TRAILS AT ASPEN RIDGE
EL PASO COUNTY, COLORADO
PLANNED UNIT DEVELOPMENT AND
PRELIMINARY PLAN

PROJECT:
TRAILS AT ASPEN RIDGE
PUD/ SP

EL PASO COUNTY
FEBRUARY 2019

ISSUE: FEBRUARY, 2019
REV1 COMMENT RESPONSE: JUNE , 2019

MAIN ENTRANCE SIGN LOCATED IN TRACT D (FRONT VIEW)

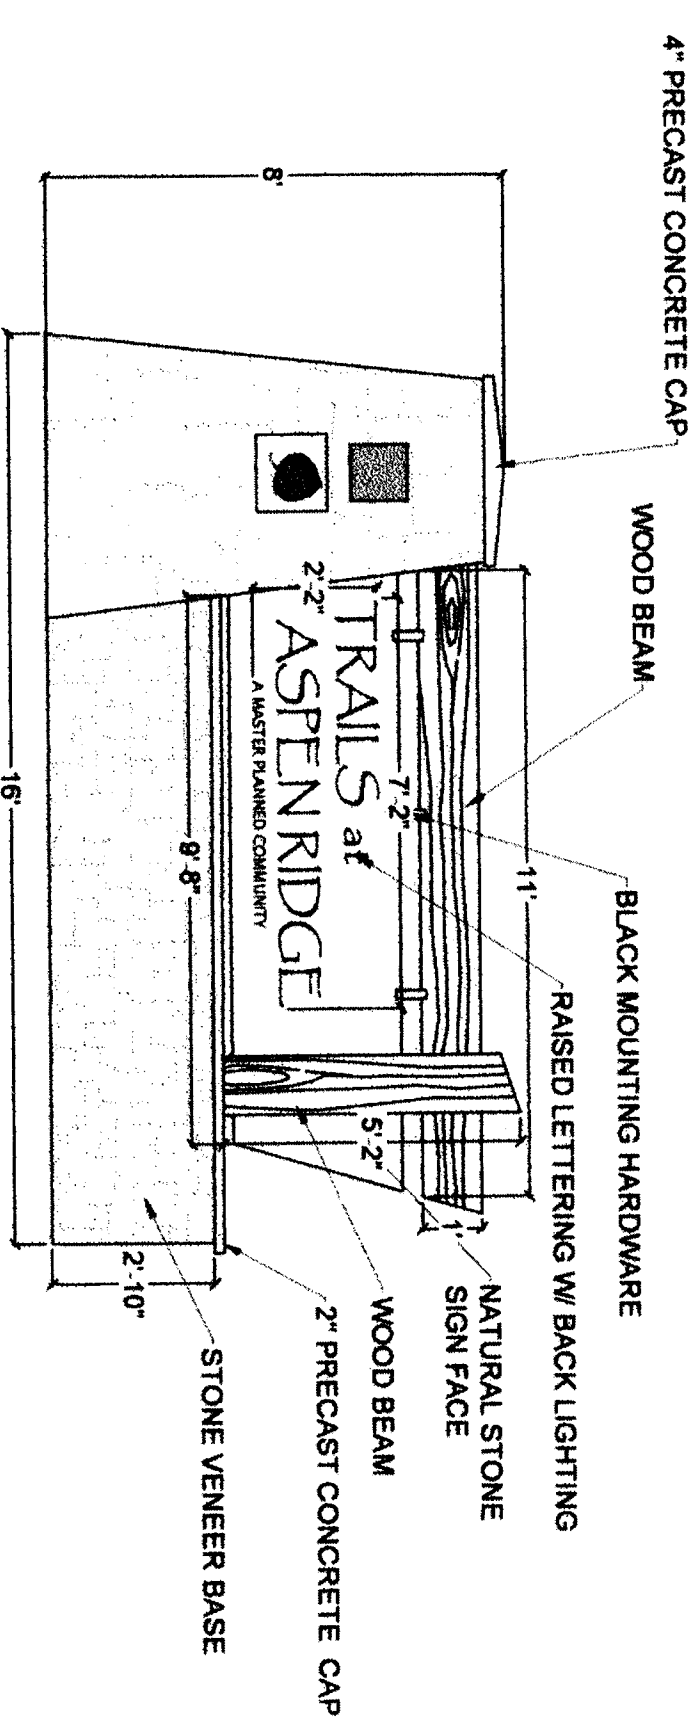
the lettering will count towards the total size of the sign. Please add dimensions to calculate the total size.

Add verbage for which tract(s) the signs will be located.

TYPICAL SECTION
(PRIVATE ROADWAY)

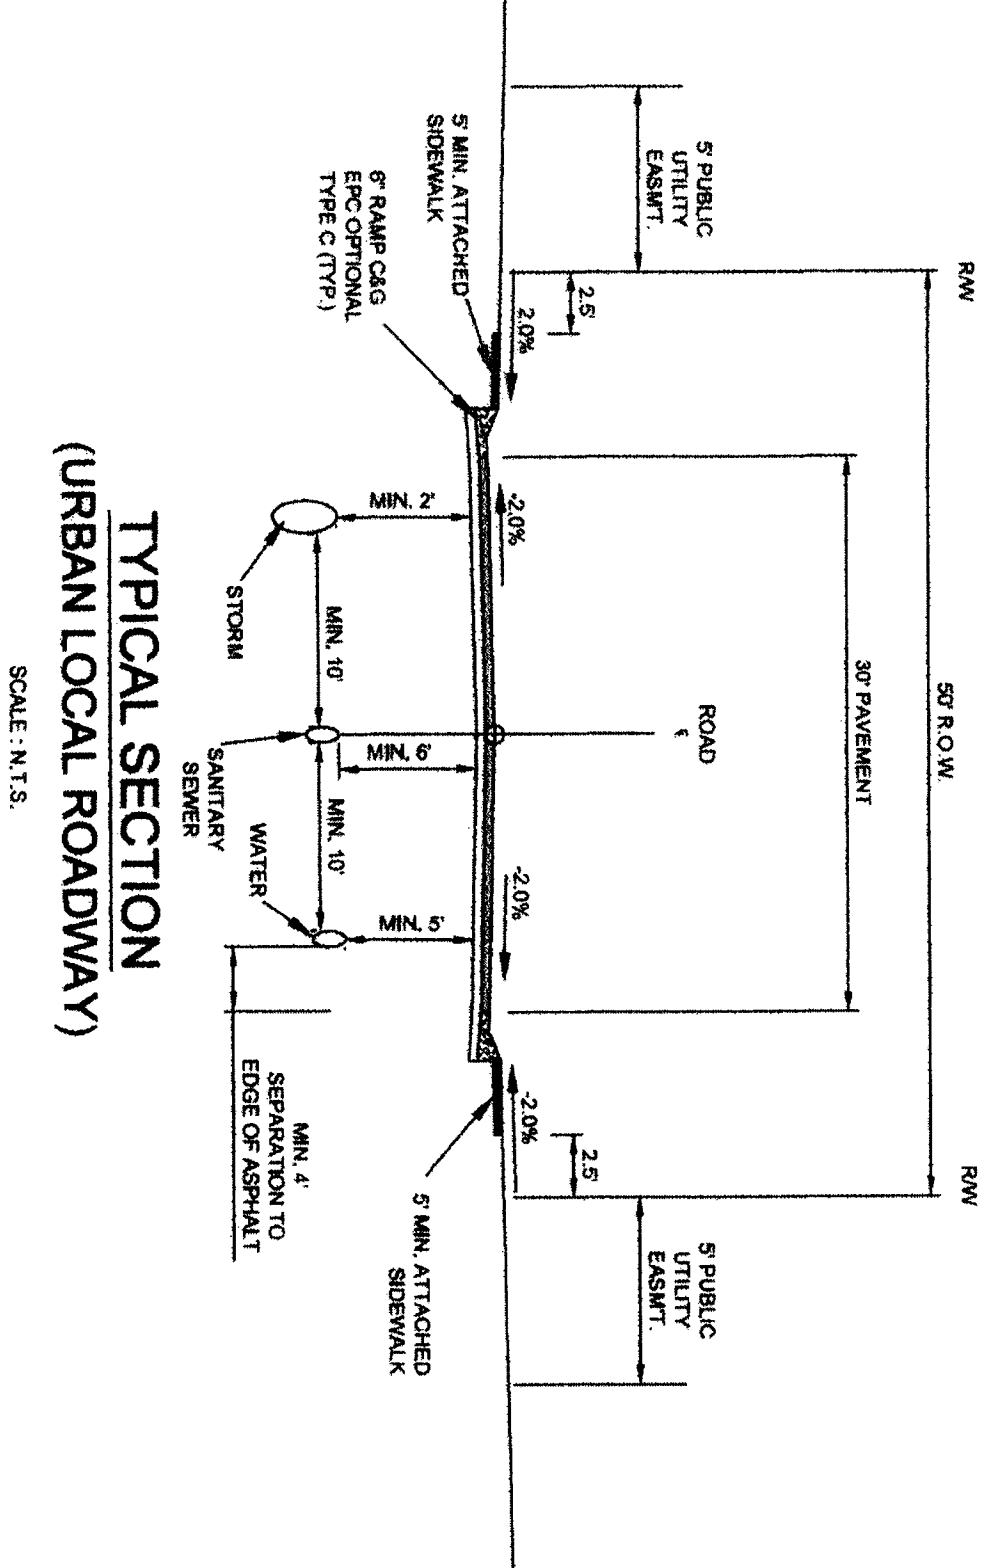
label the minimum horizontal separation and depth for stormdrain, sanitary sewer, and water

TYPICAL SECTION
(URBAN LOCAL ROADWAY)

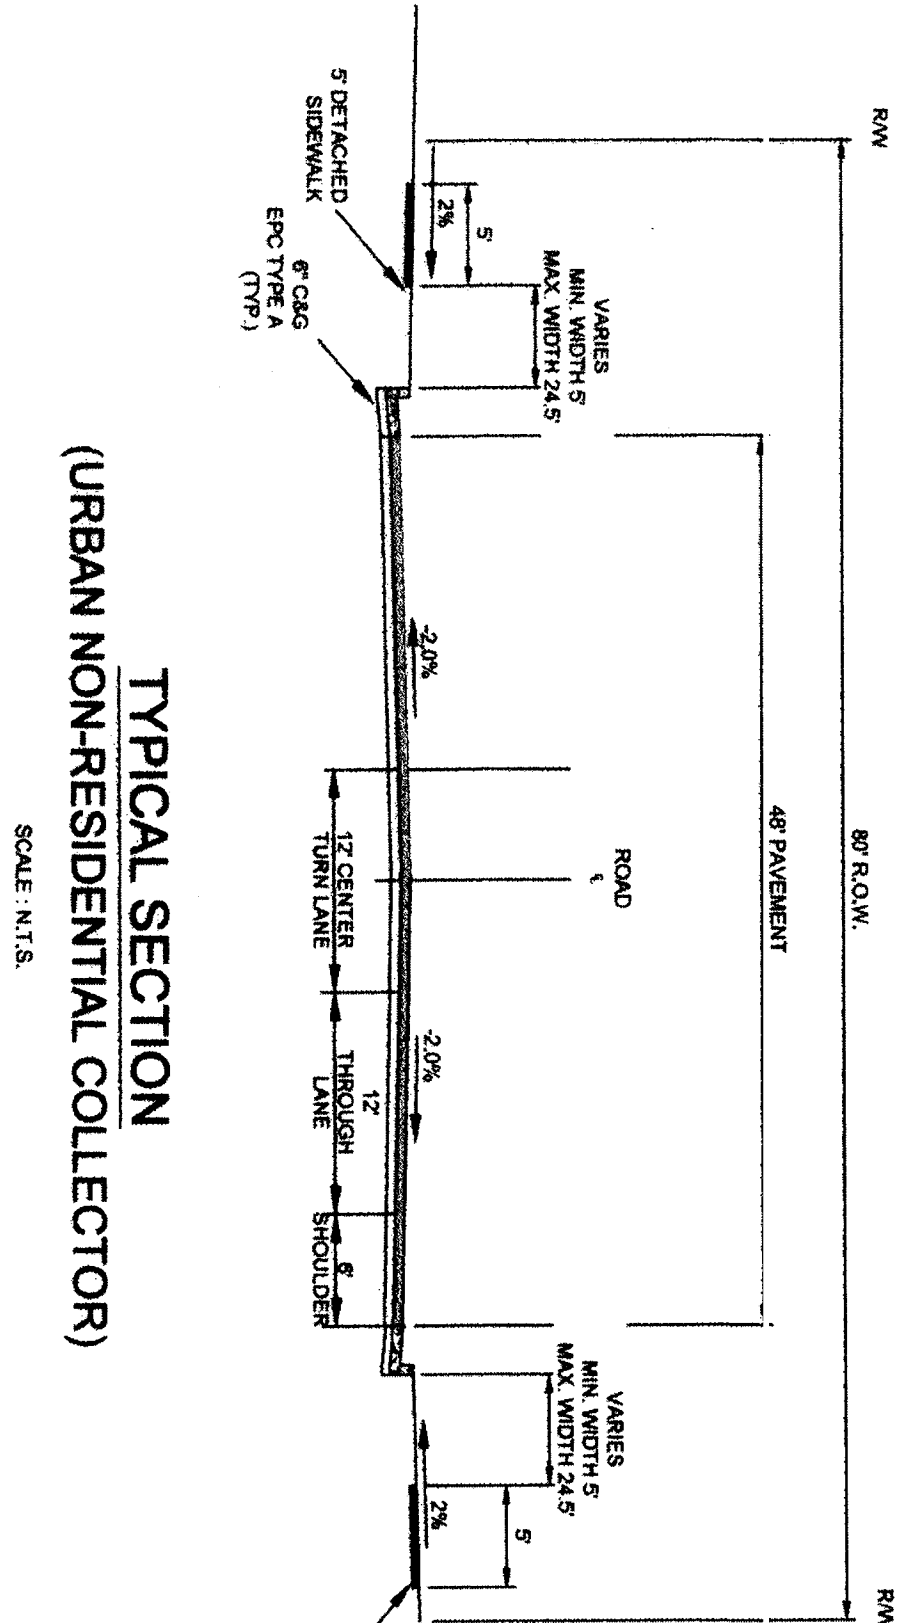
Revise to EPC Optional Type C. Unresolved. Revise all "EPC Type C" to "EPC Optional Type C"

Identify the Max width. The layout shows sidewalk extending outside the ROW within tracts.
